**DELEGATED DECISION FOR APPLICATION FOR CERTIFICATE OF
LAWFUL DEVELOPMENT**

Reference no.: 2026/CL/90838/E

Site: Elmleigh Farmhouse, 24, Stringer House Lane,
Emley Moor, Huddersfield, HD8 9SU

Description: Certificate of lawfulness for proposed erection of
detached garage

title
Site Plans - As Proposed

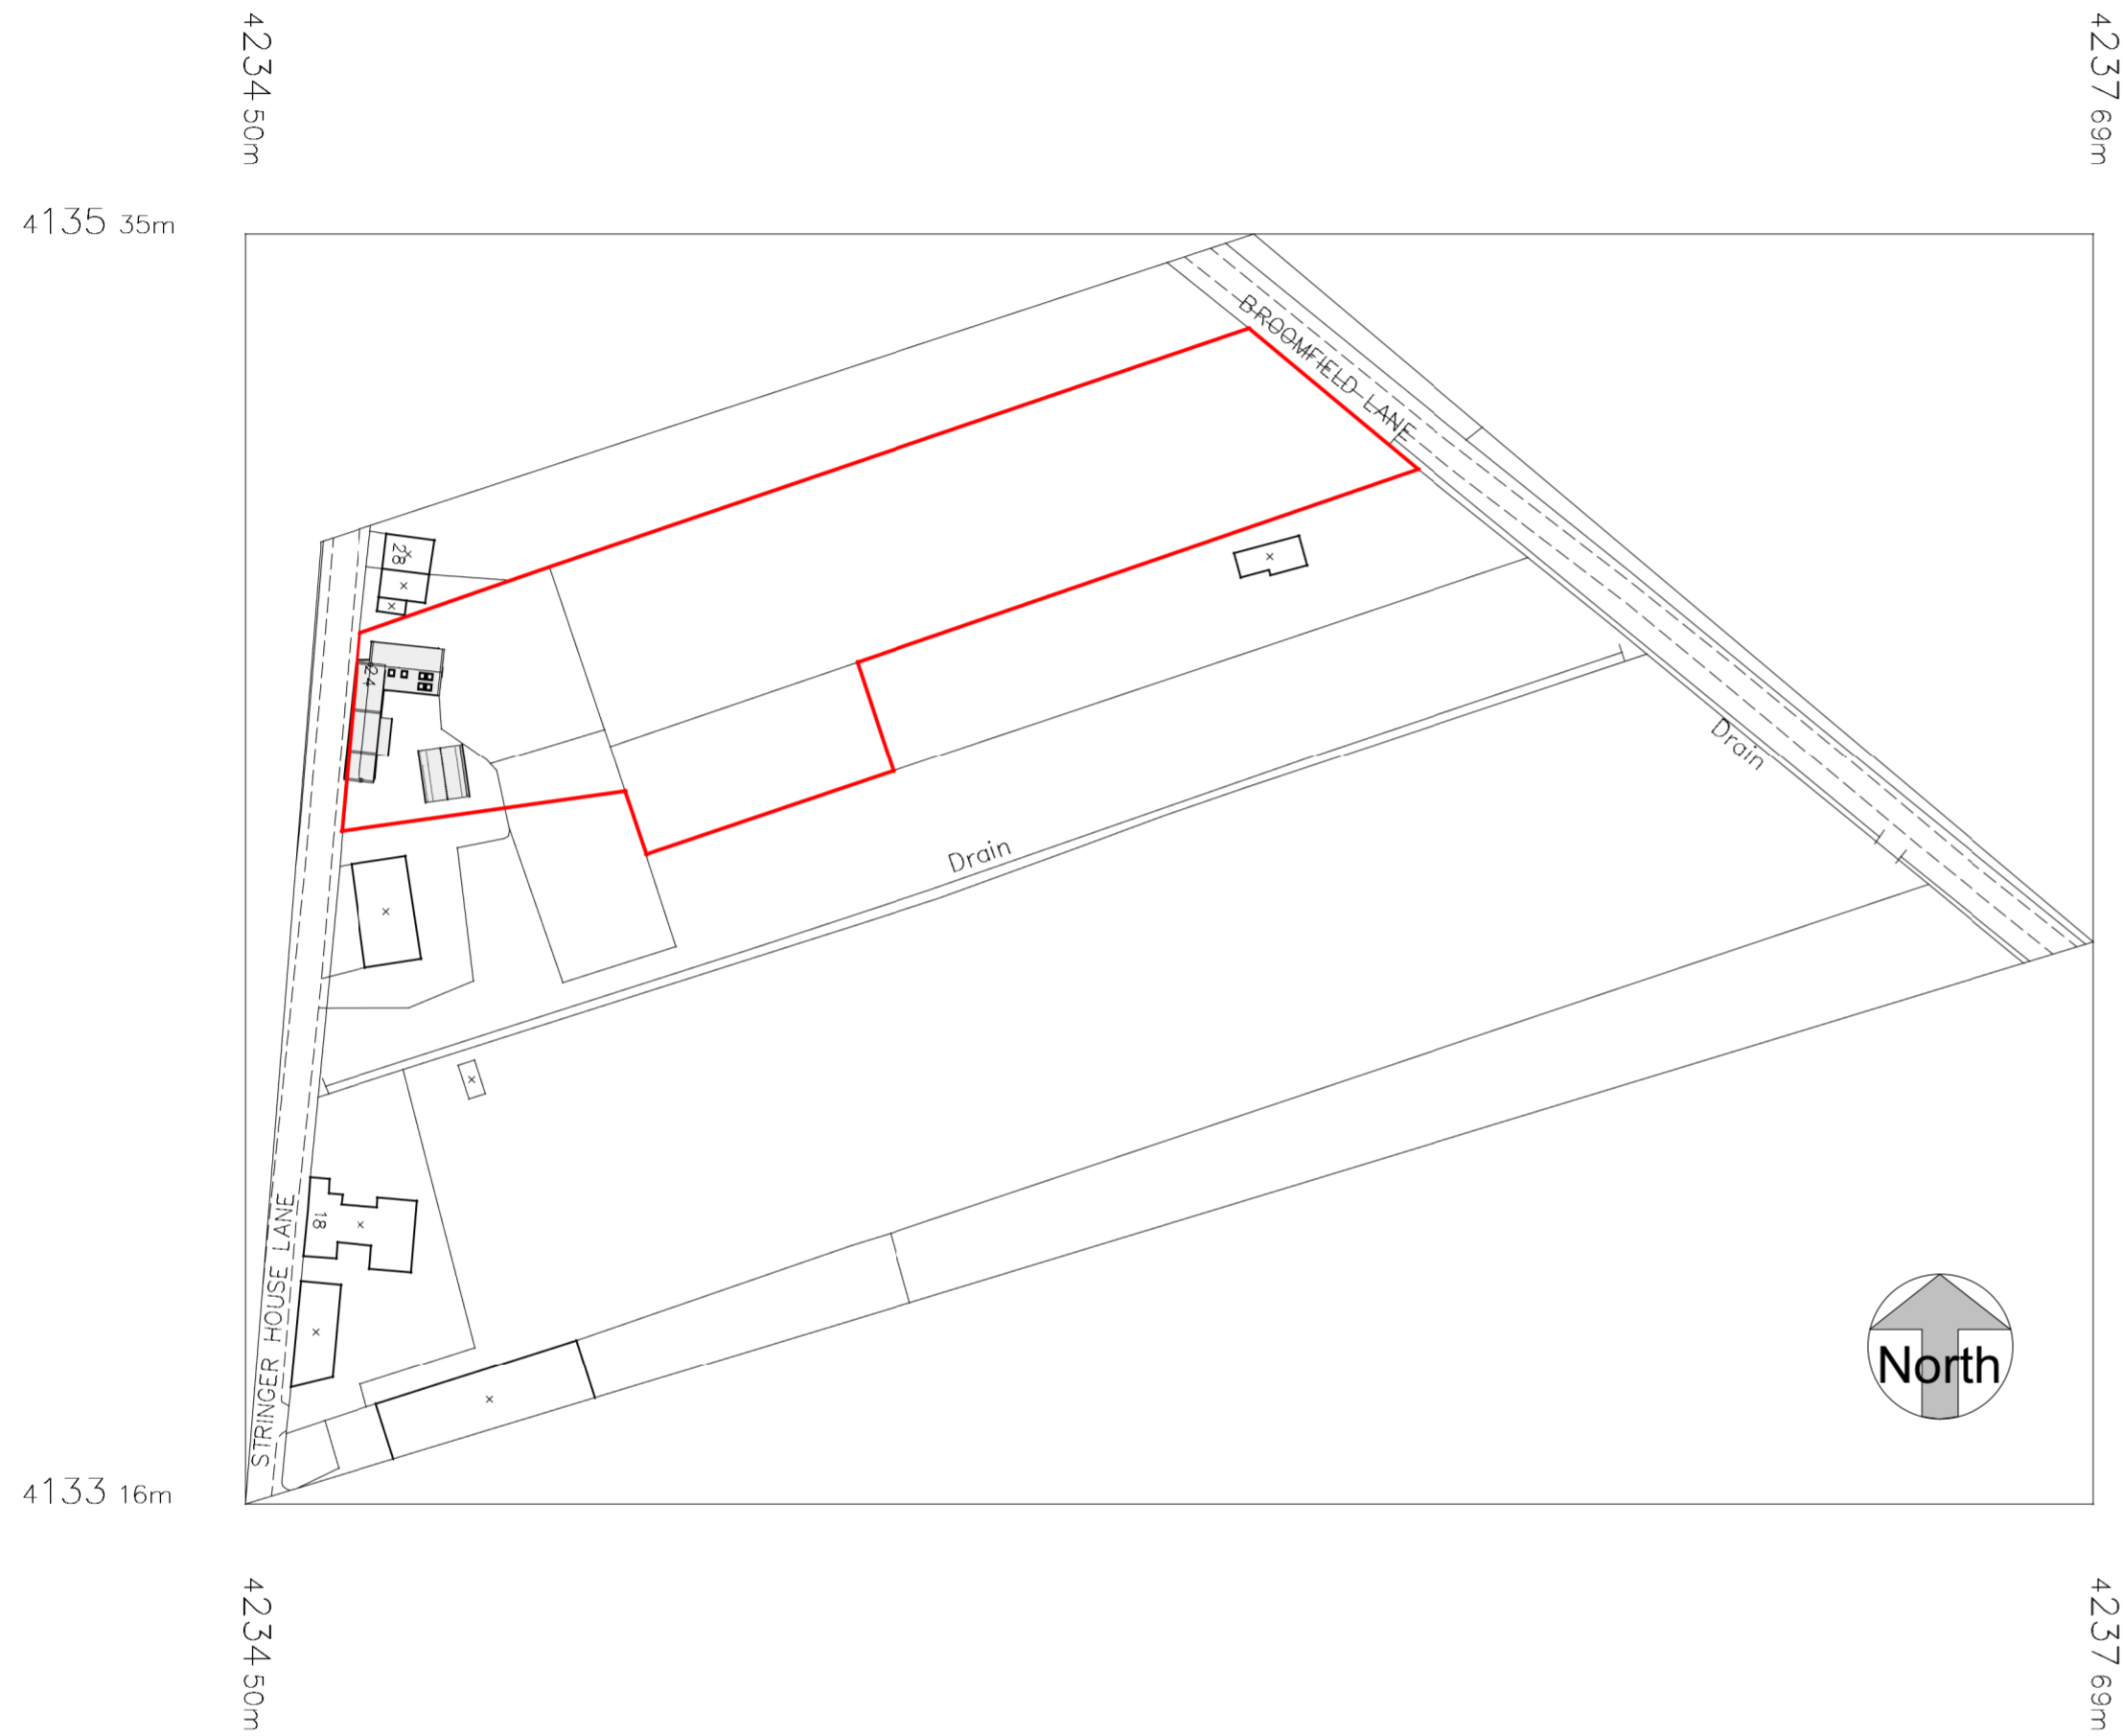
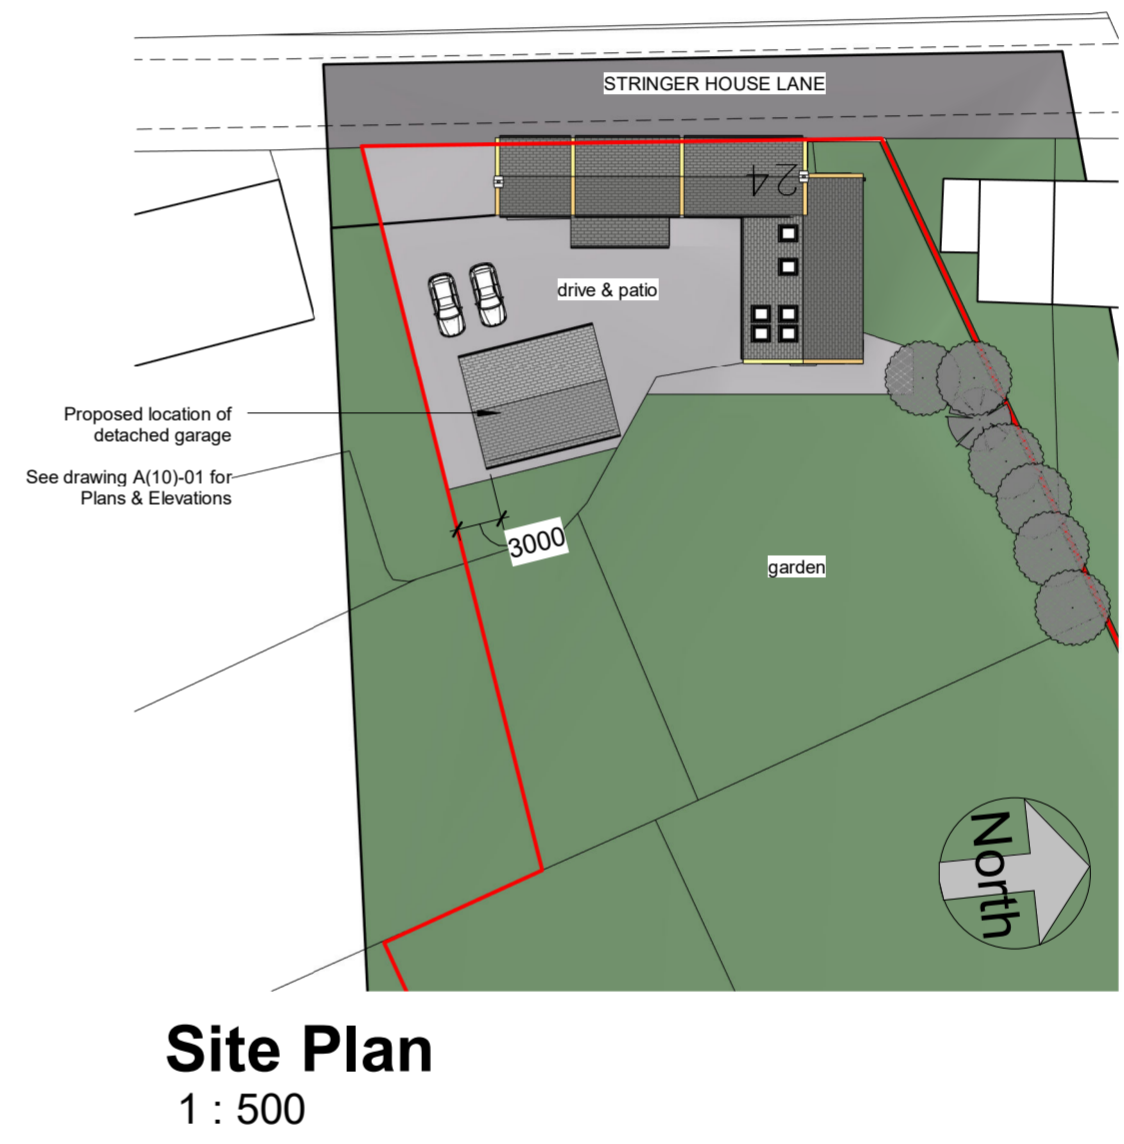
The outbuilding would be located to the south-east of the host dwellinghouse.

Comment: *No more than 50% of the curtilage would be covered by additions.*

Comment: *As previously accepted by the LPA under planning reference 2023/90973, it is not considered that the building would be situated on land forward of the principal elevation of the dwellinghouse.*

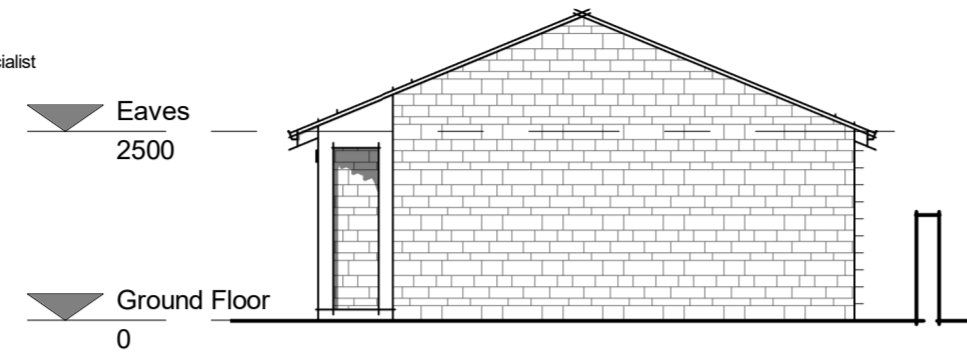
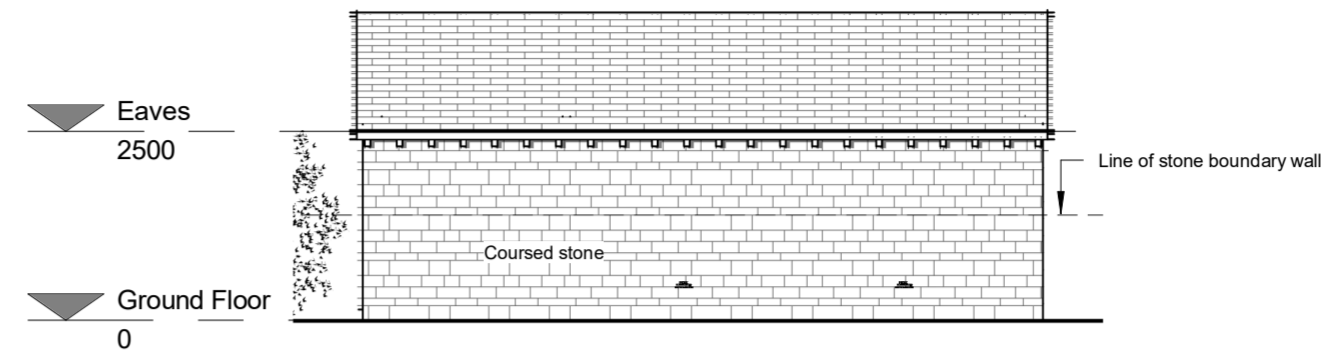
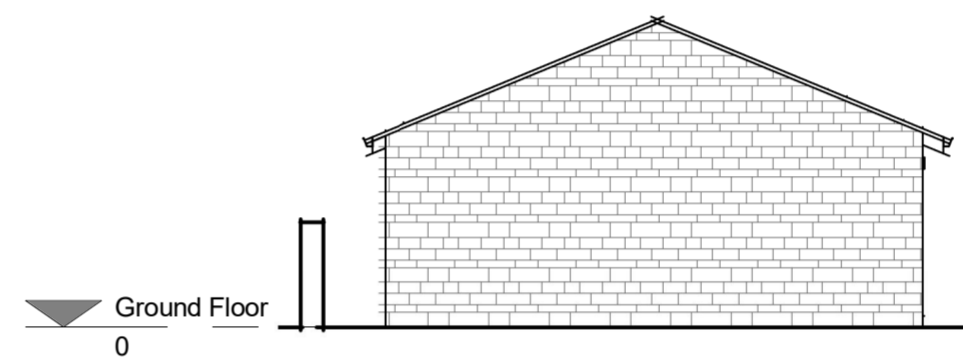
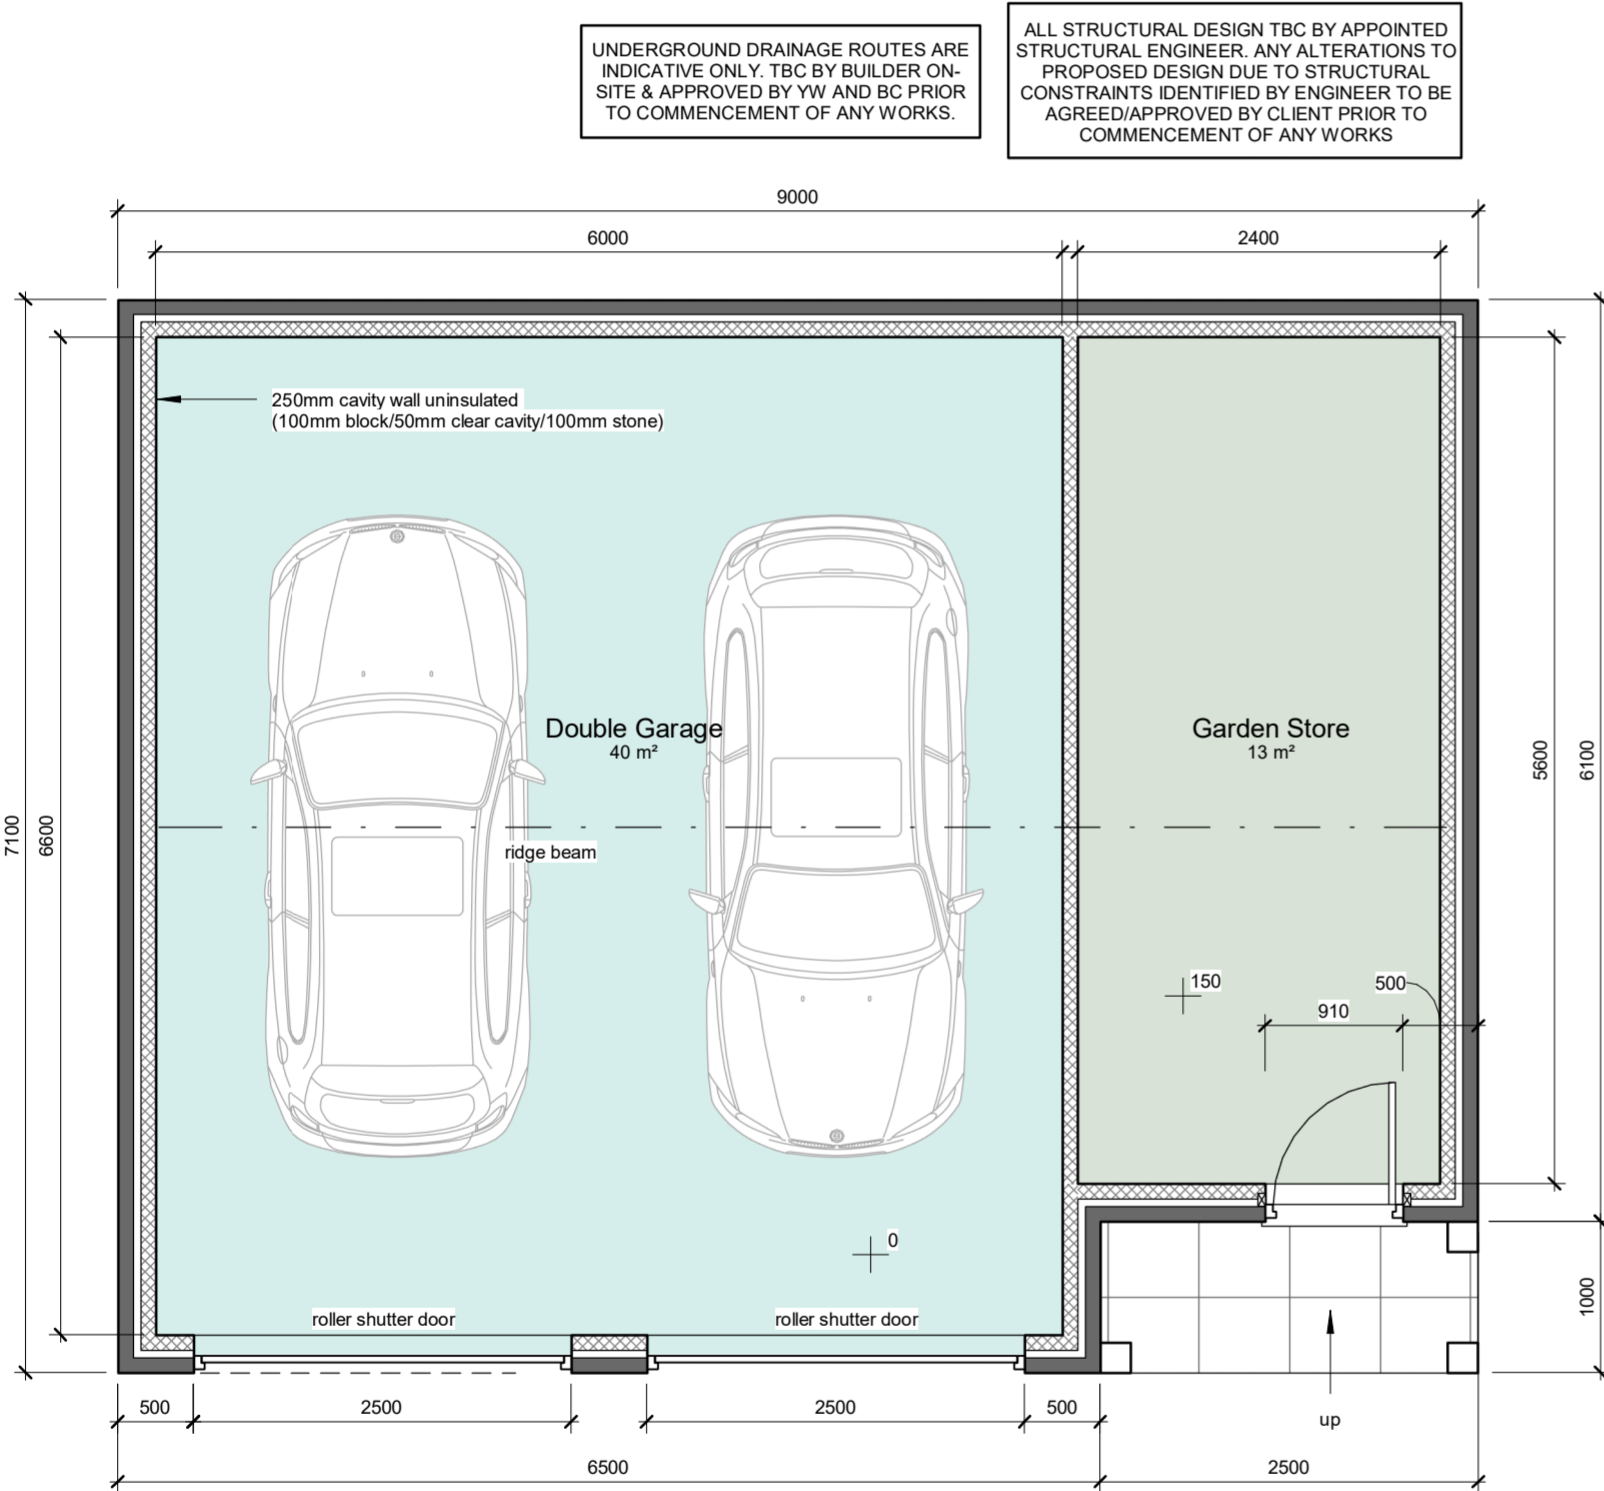
The outbuilding would be located within the rear amenity space of the property and would be rectangular in its design. The outbuilding would have a total width of 9 metres, depth of 7 metres with an eaves height of 2.5 metres and overall height of 4 metres.

Comment: *The building would not have more than one storey.*

Comment: *The height of the building would not exceed 4 metres and is not located within 2 metres of the boundary of the dwellinghouse.*

Comment: *The height of the eaves would not exceed 2.5 metres.*
